BELMORGAN PROPERTY DEVELOPMENT

DWYERS & OXFORD SITES

CONCEPT ACCESS REVIEW

Morris-Goding Accessibility Consulting

DRAWING NO. A-DA-2.10

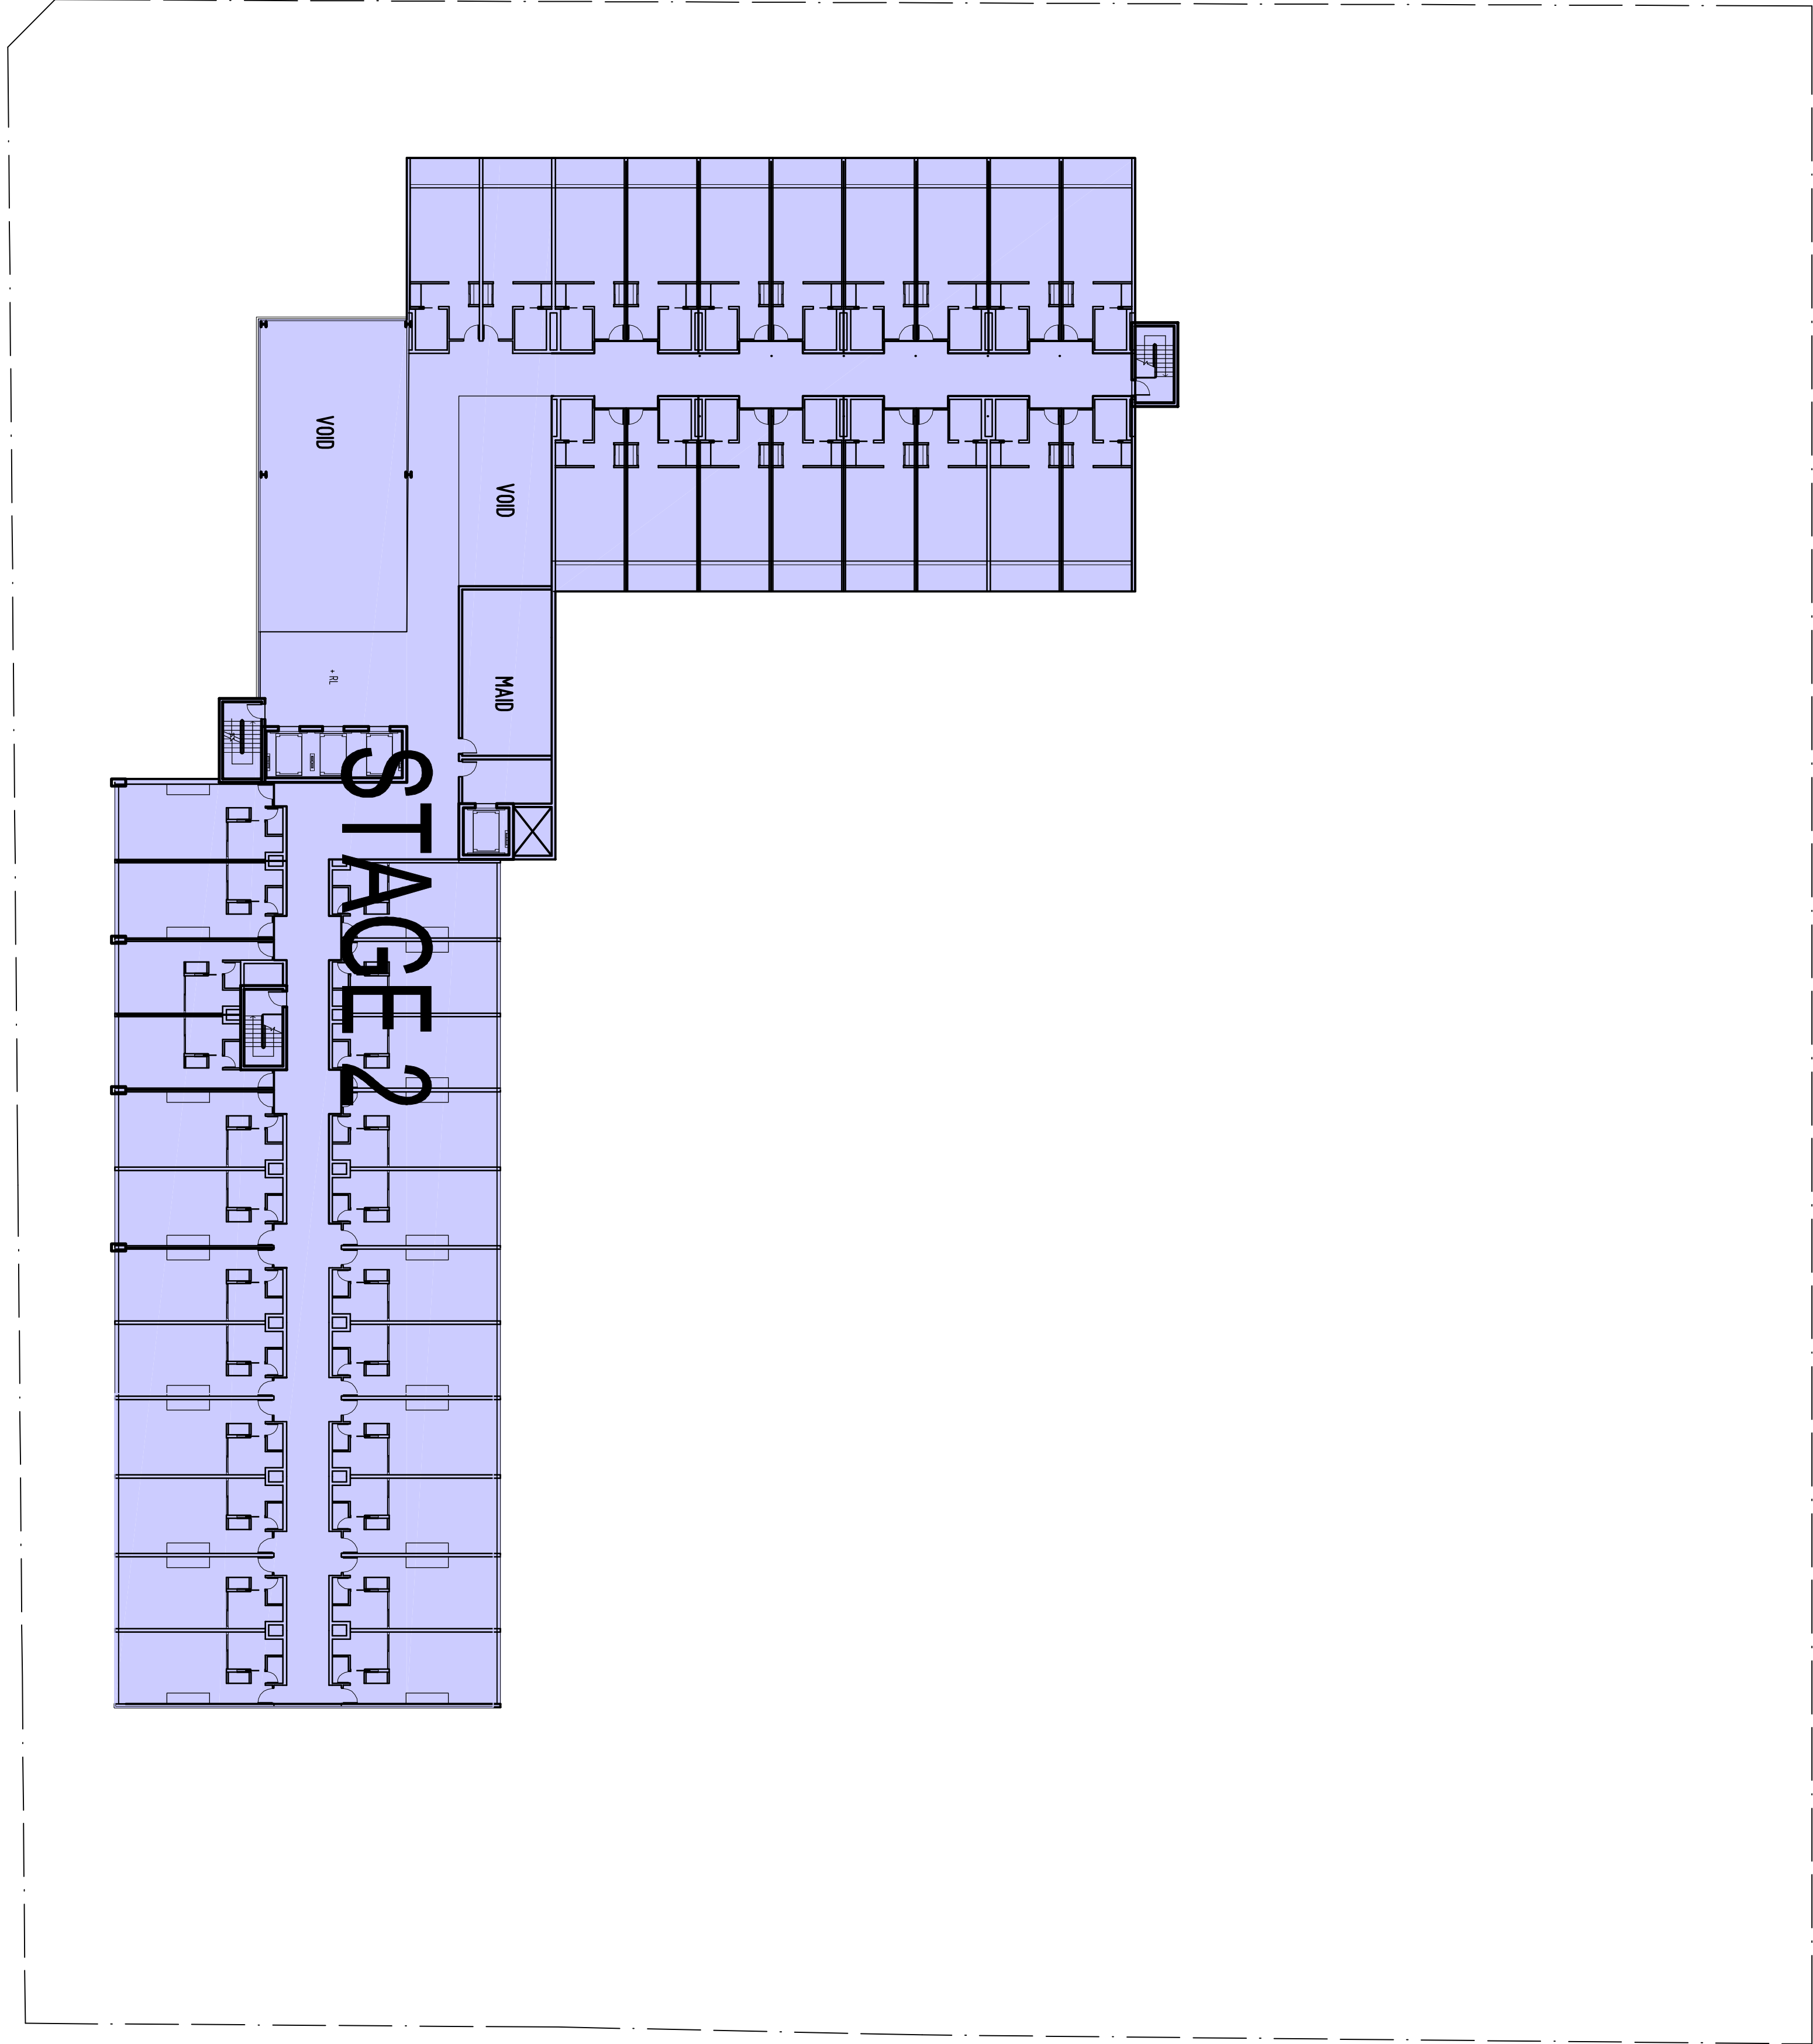
The paths of travel leading to hotel rooms of the Dwyer's Site are accessible and continuous. Modifications will be required to guest rooms to be able to achieve suitable design of 8 accessible guest rooms.

The paths of travel leading to the residential units of the Oxford Site are accessible and continuous. Modifications will be required to be able to achieve the provision of 5 adaptable units in accordance with AS4299 and Wollongong City Council DCP 2007.

DRAWING NO. A-DA-2.05 G

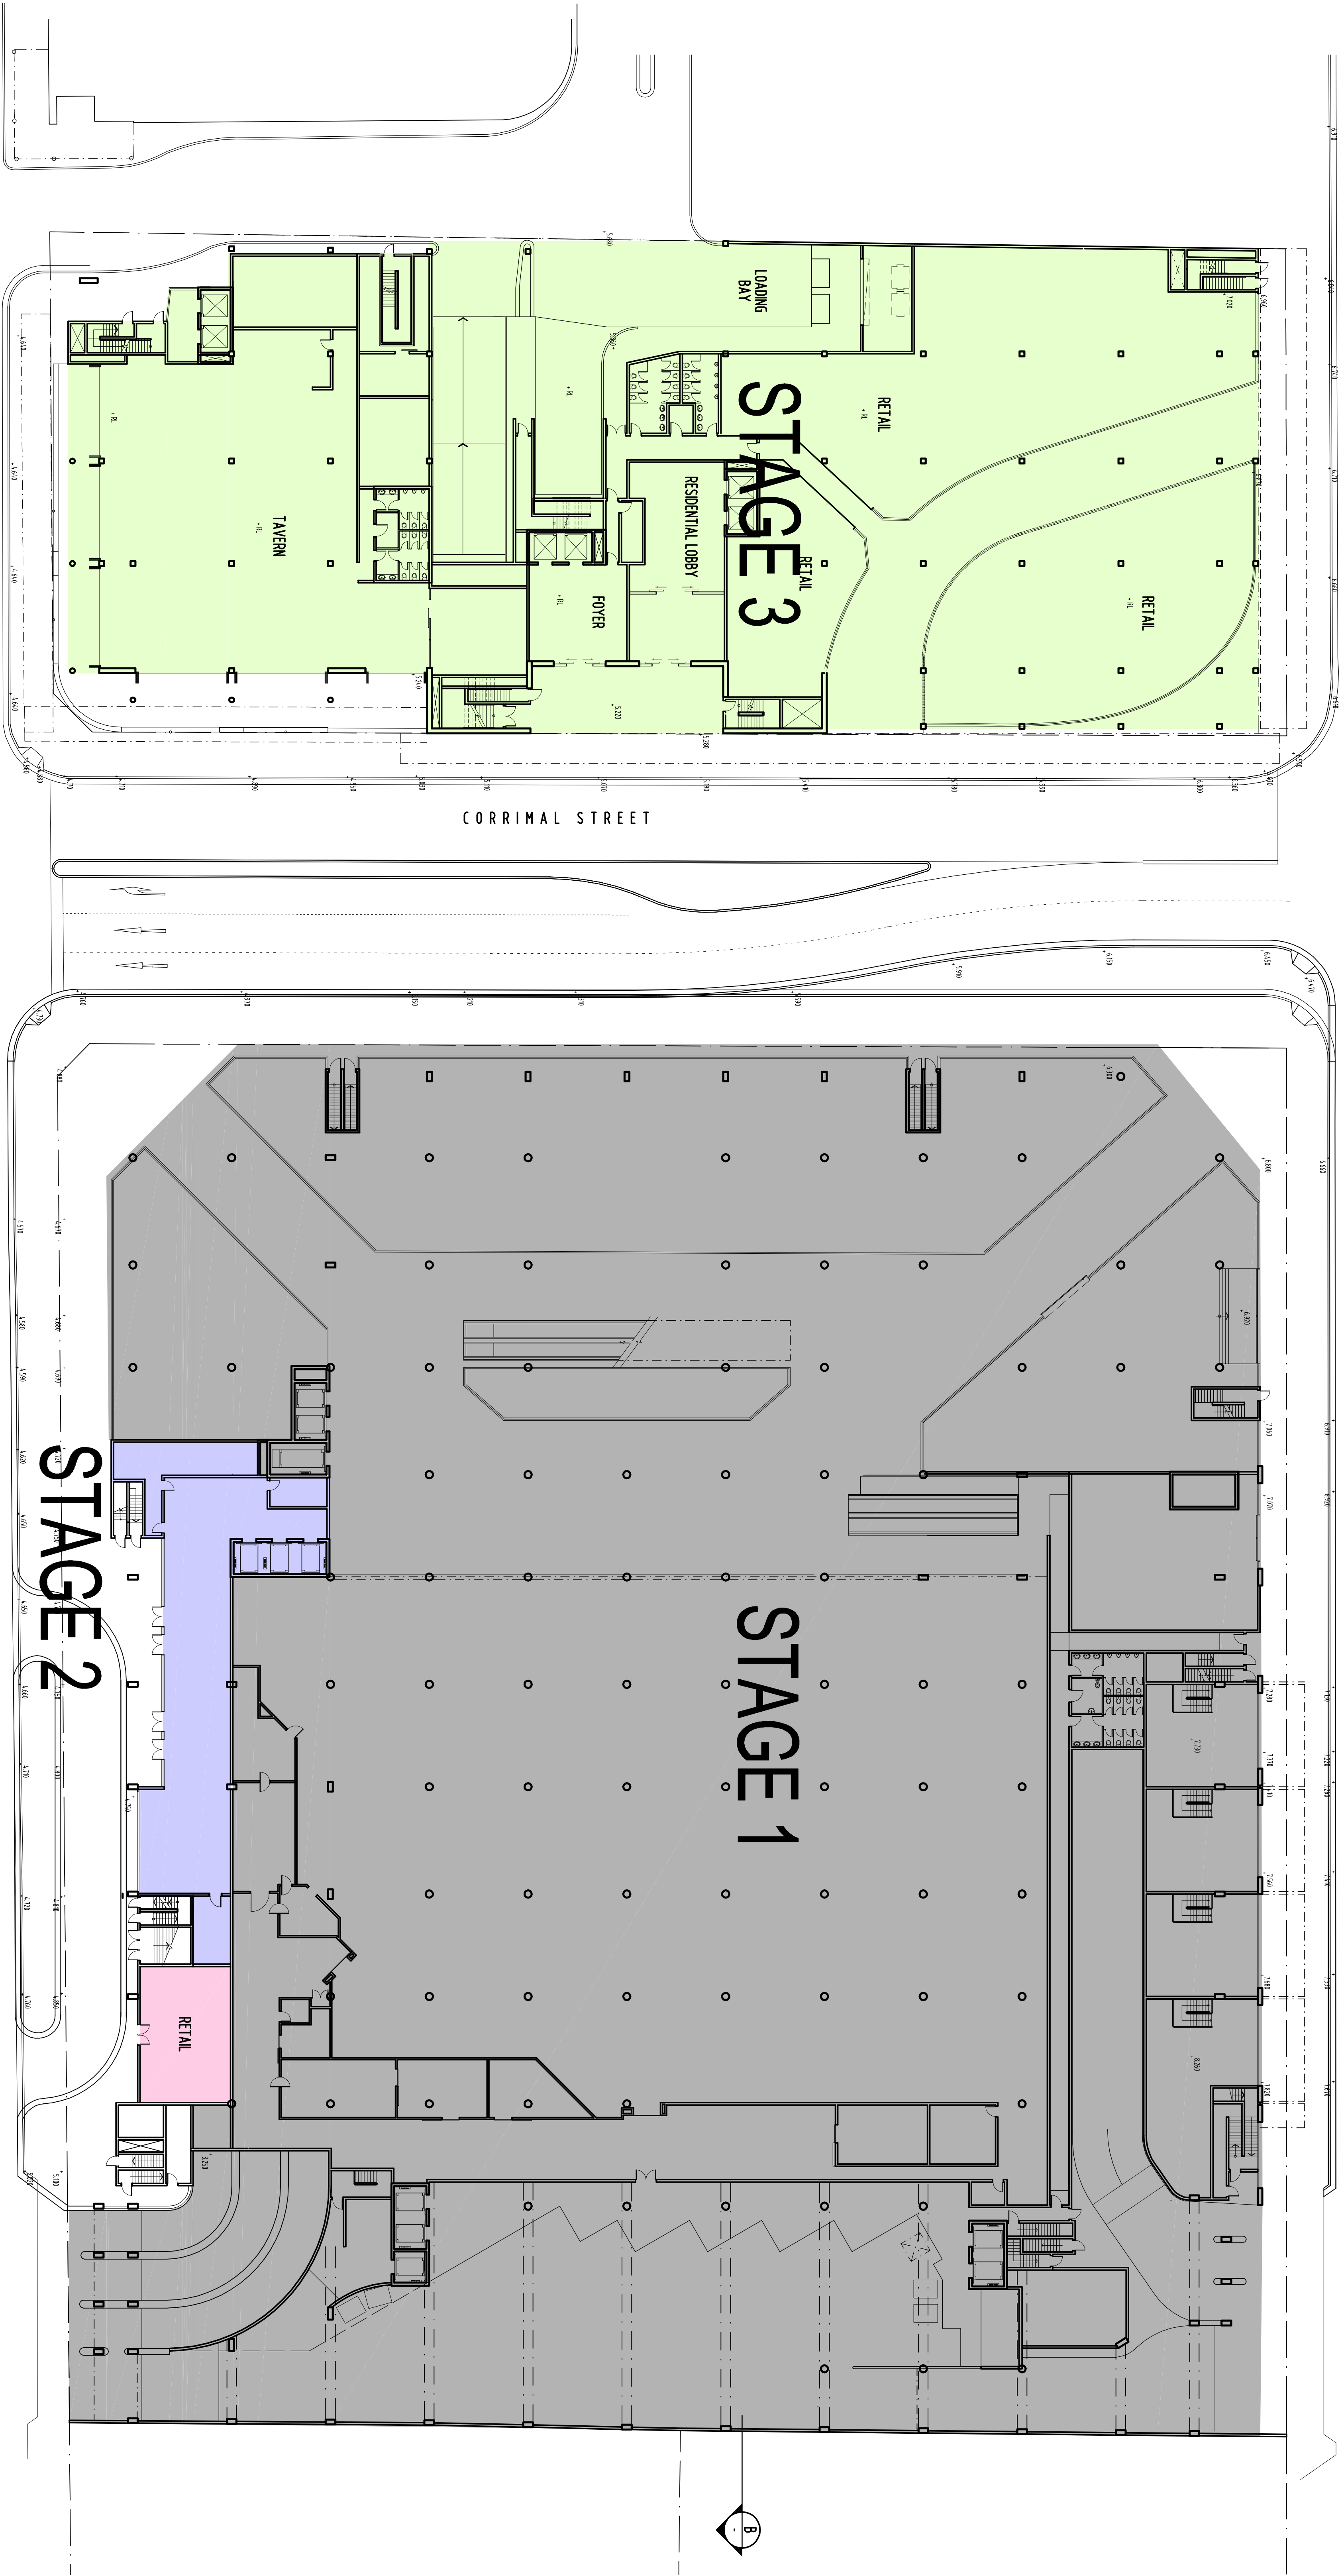
There is a basement restaurant/bar space on Dwyer's site level 1 located on the basement level 1, and is accessed by stair only. Wheelchair access into this area needs a restricted use vertical platform lift compliant with AS1735.16. This is achievable.
